**Notification of Modification to Australian Technology Park
(SSD 7317 MOD 12)**

Thank you for your letter requesting Transport for NSW (TfNSW) review and comment on the above.

Dwg No.	L_Base Master
Dwg Name	Landscape Plan
Project	Australian Technology Park
Issue	FOR INFORMATION
Revision	-
Scale	1:500 @ A0
Date	01.06.2017
Drawn/Checked	MF/OM

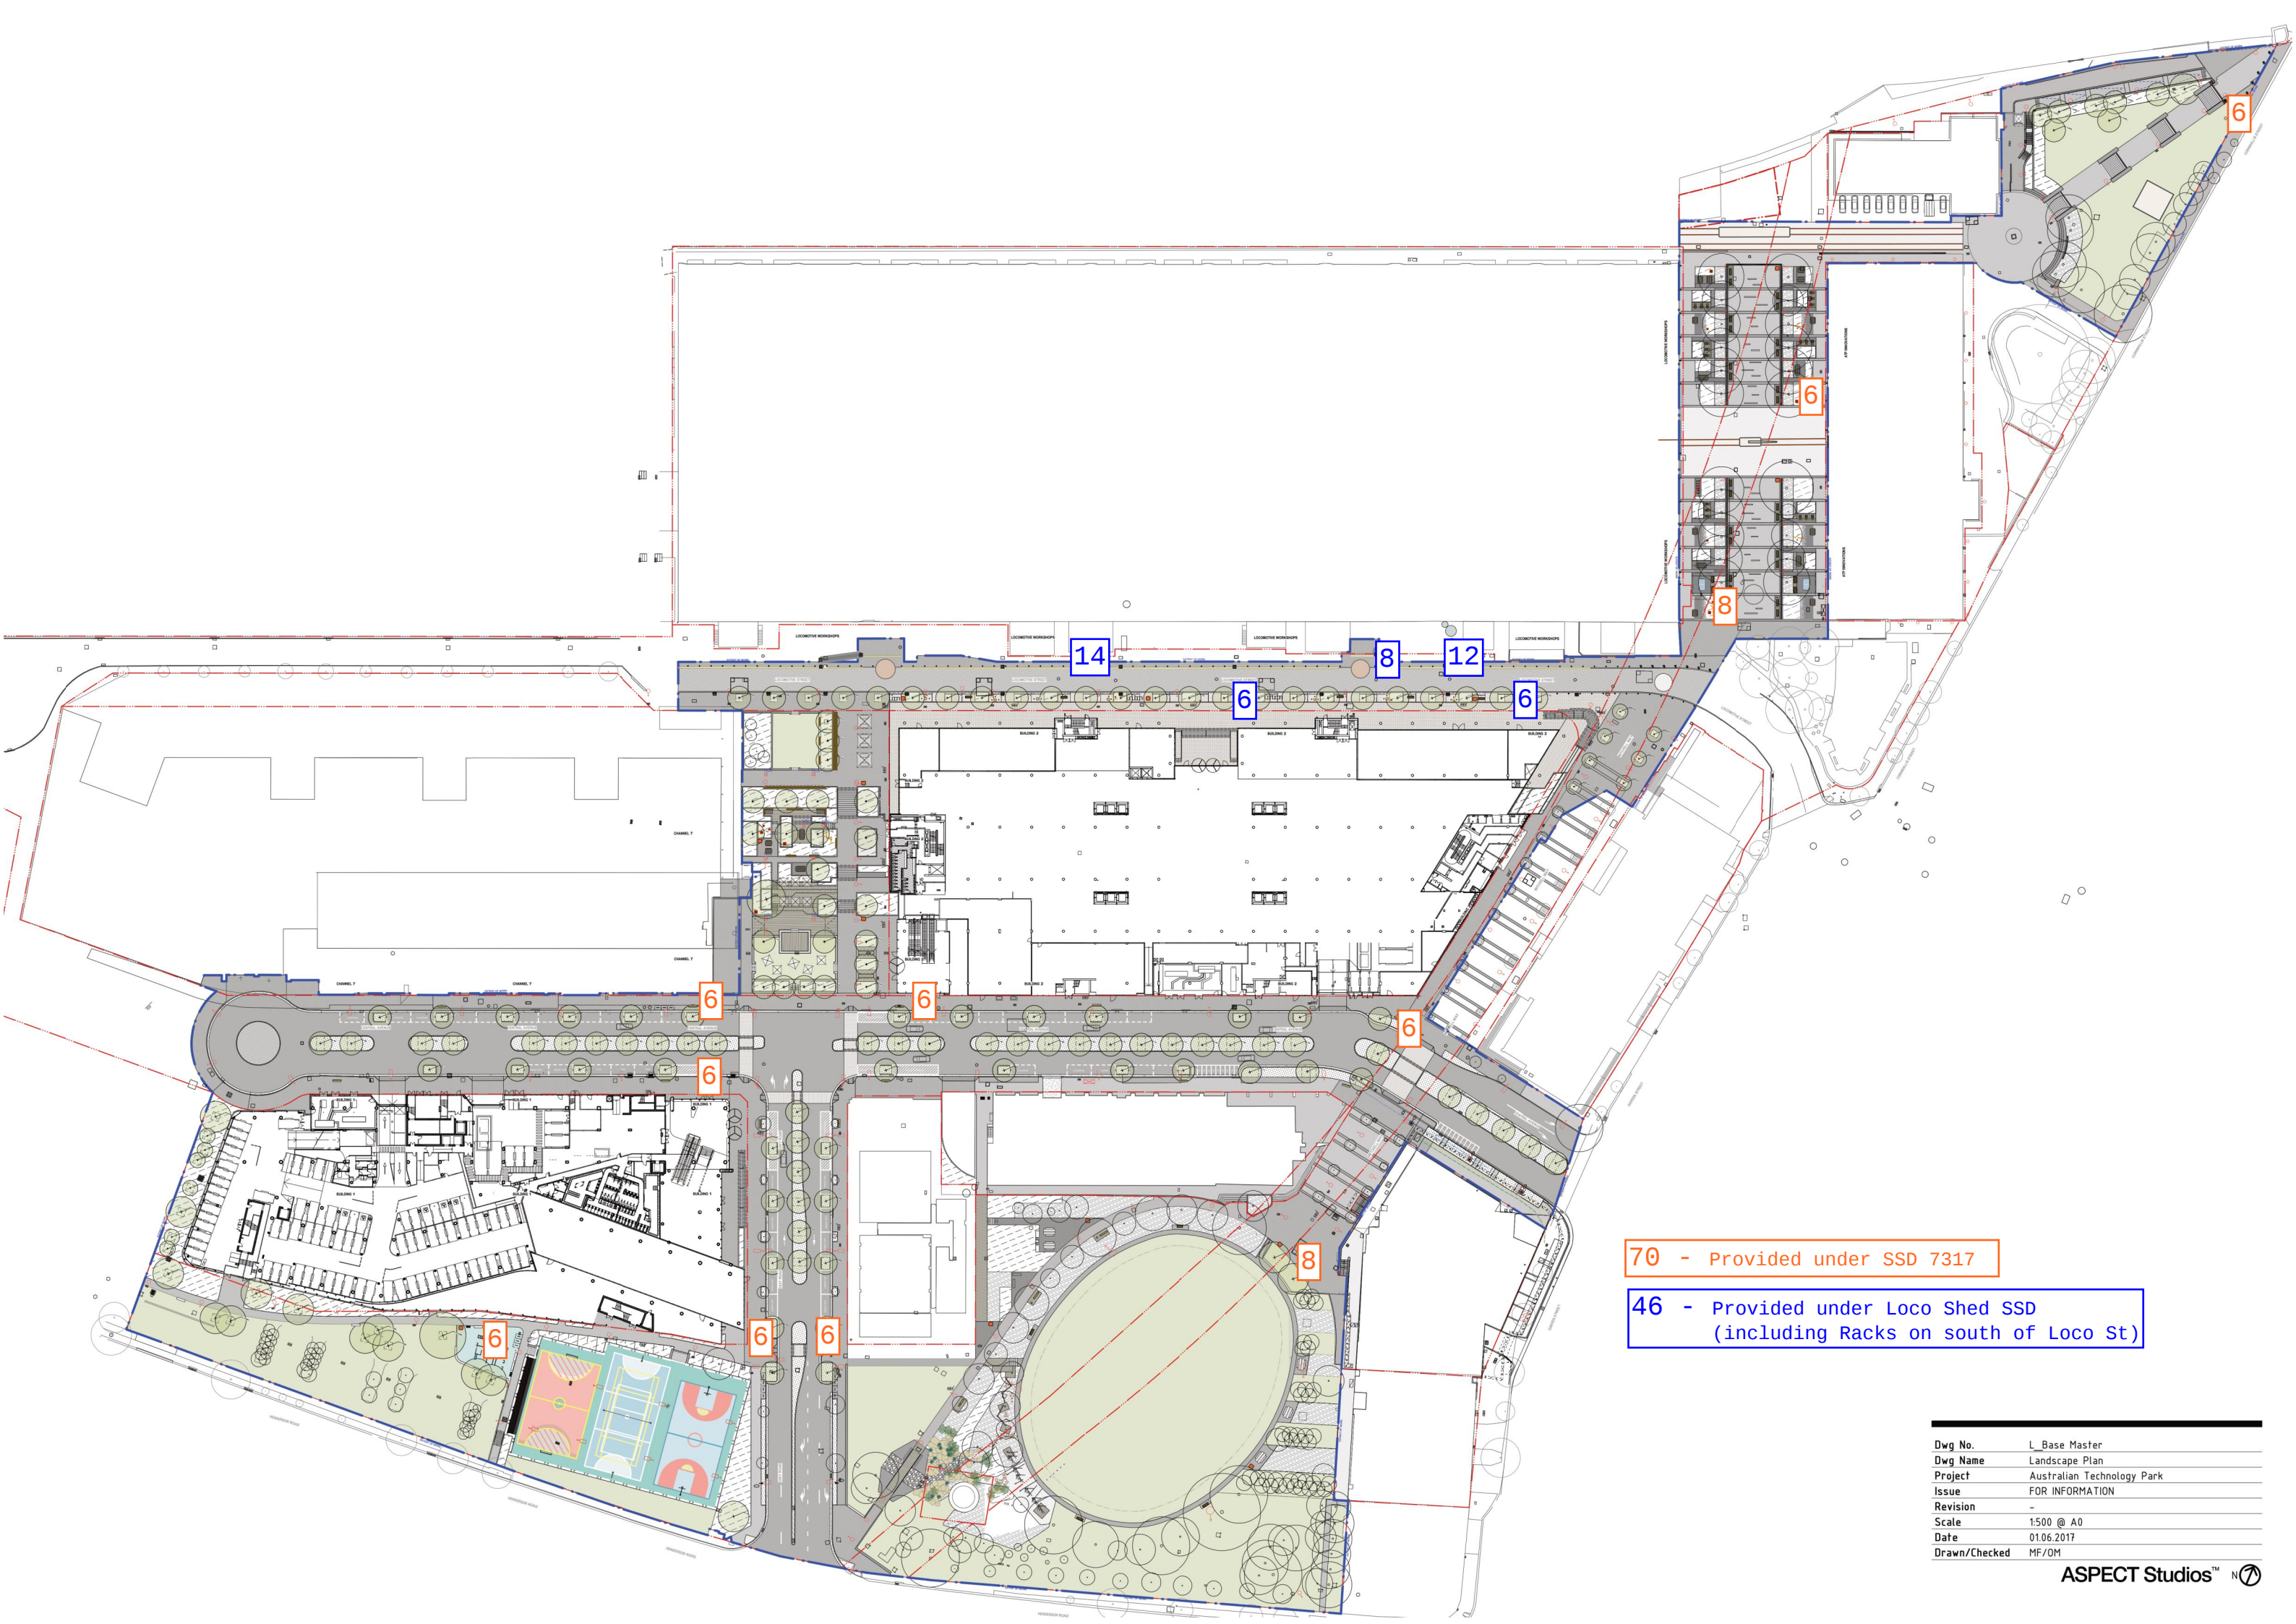
TfNSW has been working with the applicant to address Condition B52 of the Consent. It is noted that no marked bus parking spaces are shown in the Landscape Masterplan. TfNSW understands that the applicant would provide two (2) bus spaces within the precinct to support the subject development; one on Central Avenue and the other on Davy Road.

- The two (2) proposed bus spaces on Central Avenue and Davy Road be designed in accordance with Austroads Guides to support the operation of 14.5m long buses including, entries and exits to the Australian Technology Park Precinct and along internal roads;

- Provision of bus spaces on Locomotive Street also be considered for the southern kerb of Locomotive Street which is located within the area of the Landscape Masterplan and Public Domain Plan required under Condition B53 of the Consent for the subject development;

- The Landscape Masterplan and Public Domain Plan include bus spaces on the southern kerb of Locomotive Street to support the proposed land uses within the Locomotive Workshops, in consultation with TfNSW; and
